**Mangoola Coal Project Modification 6 (06\_0014 MOD 6)  
Environmental Assessment Review**

NSW Trade & Investment, Division of Resources & Energy (DRE) has reviewed the *Mangoola Coal Modification 6 Environmental Assessment* (EA) dated May 2013 and provides the following comments which are directed at specific areas of DRE responsibility for this proposal.

Proposed mine plan - Final landform

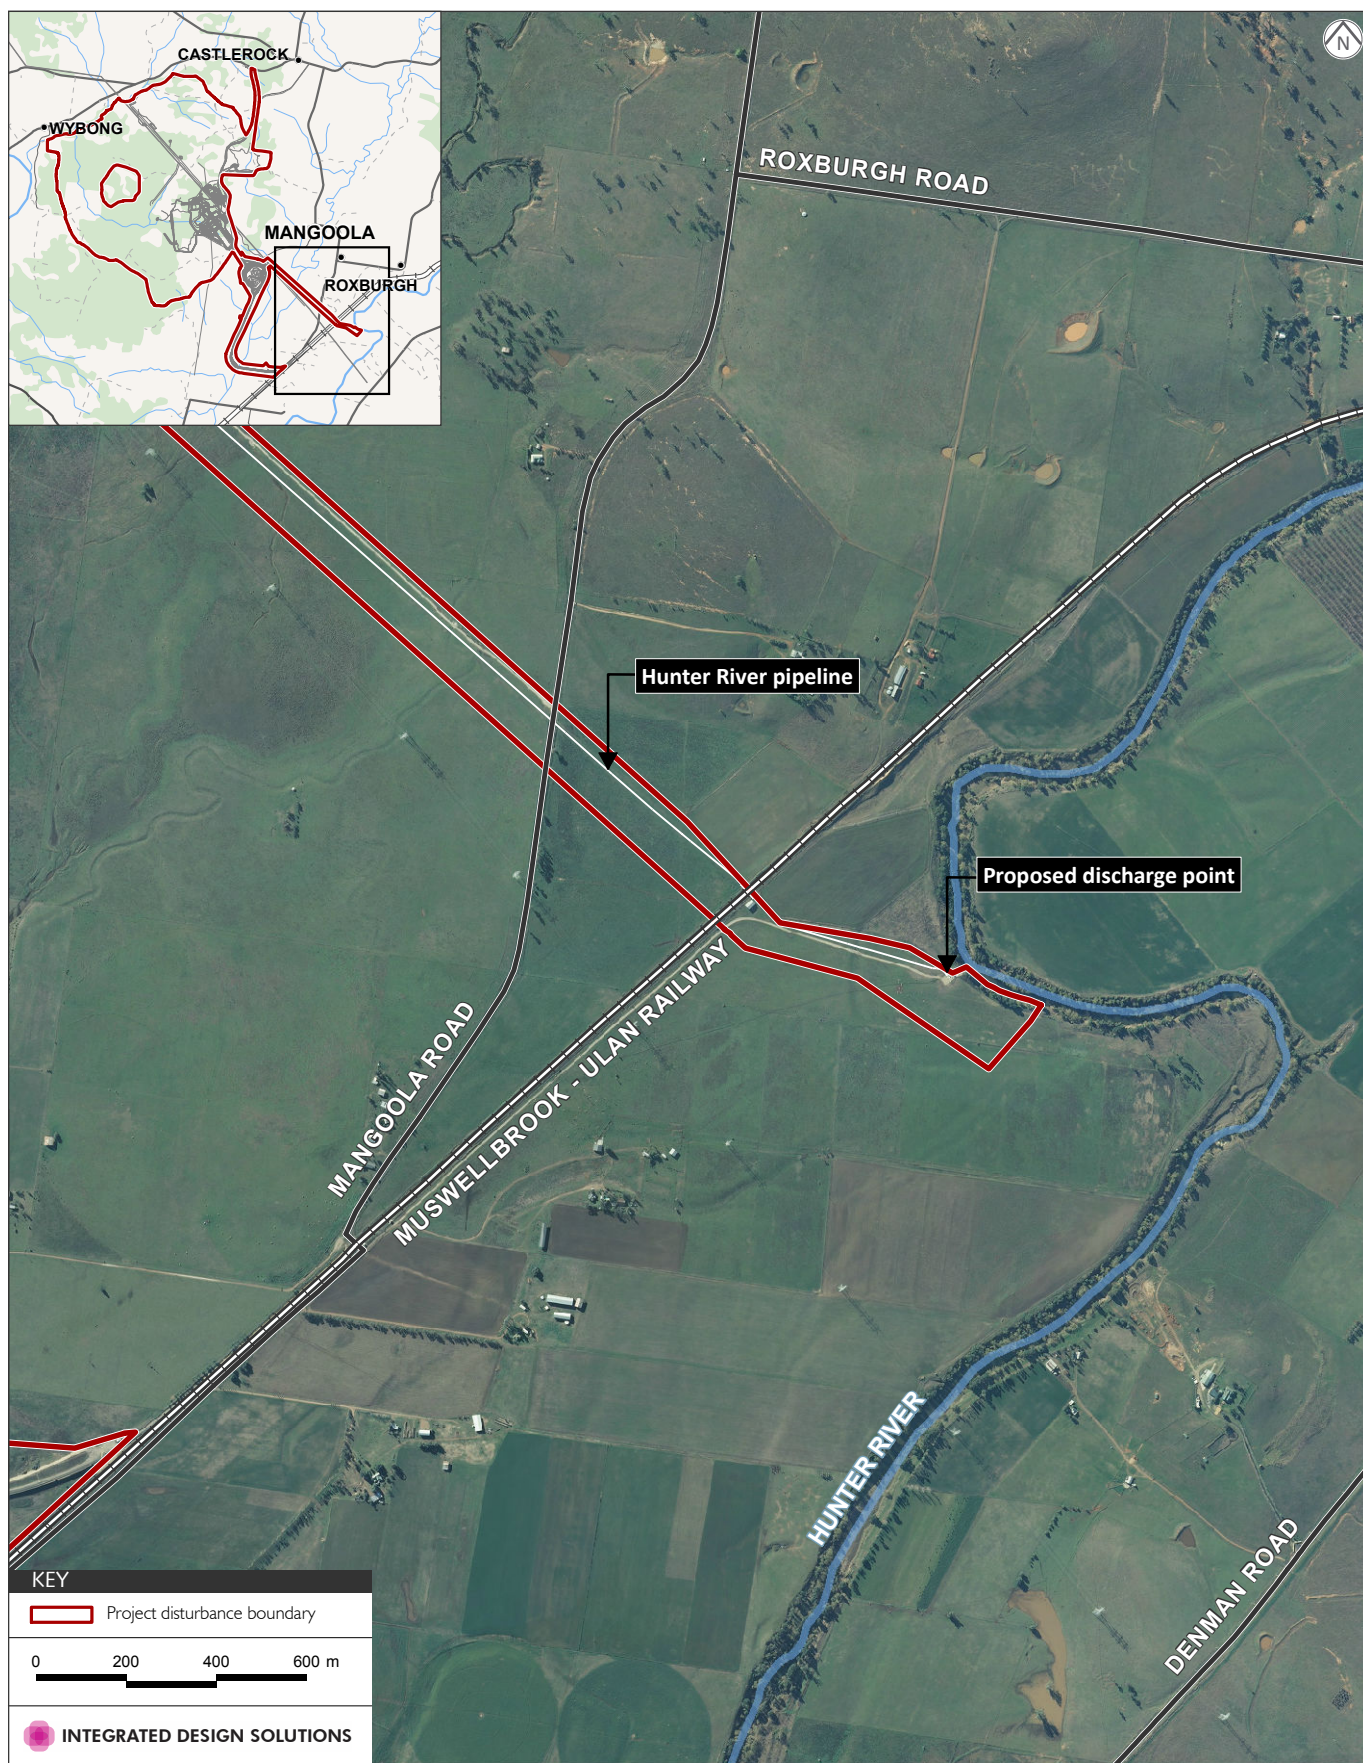
The EA has not fundamentally addressed the impact to rehabilitation as a result of increased coal extraction and changes to the landform, or stockpiling of ROM coal. DRE considers that the following issues should be addressed prior to the granting of any planning approval:

- assess the impact of the final landform on surface water management to reduce the potential for soil erosion and reliance on infrastructure such as drop structures.
- assess the impact to rehabilitation as a result of changes to the rehabilitation schedule.

- revise the final landform to make the final landform more consistent with the surrounding landscape.
- assess the potential for spontaneous combustion related to stockpiling of ROM coal and identify management actions to minimise the risk and how this would be monitored.

DRE considers that it is important for emplacement design to be sympathetic with the surrounding topography. DRE accepts the conceptual landform design outlined in the EA, however the Proponent should be aware that as part of the MOP, DRE will require further detail regarding emplacement design, with specific reference to vertical relief and drainage.

- address all aspects of rehabilitation and mine closure, including post mining land use assessment, rehabilitation objectives, completion criteria and rehabilitation monitoring;
- include a final landform design that is sympathetic with the surrounding topography of the area and considers natural drainage design and relief patterns and principles;
- include a Life of Mine Tailings Strategy that:
  - I. must be prepared by a team of suitably qualified and experienced persons.
  - II. addresses all aspects of life of mine tailings incorporating design, operation, water balance and decommissioning including rehabilitation and closure.
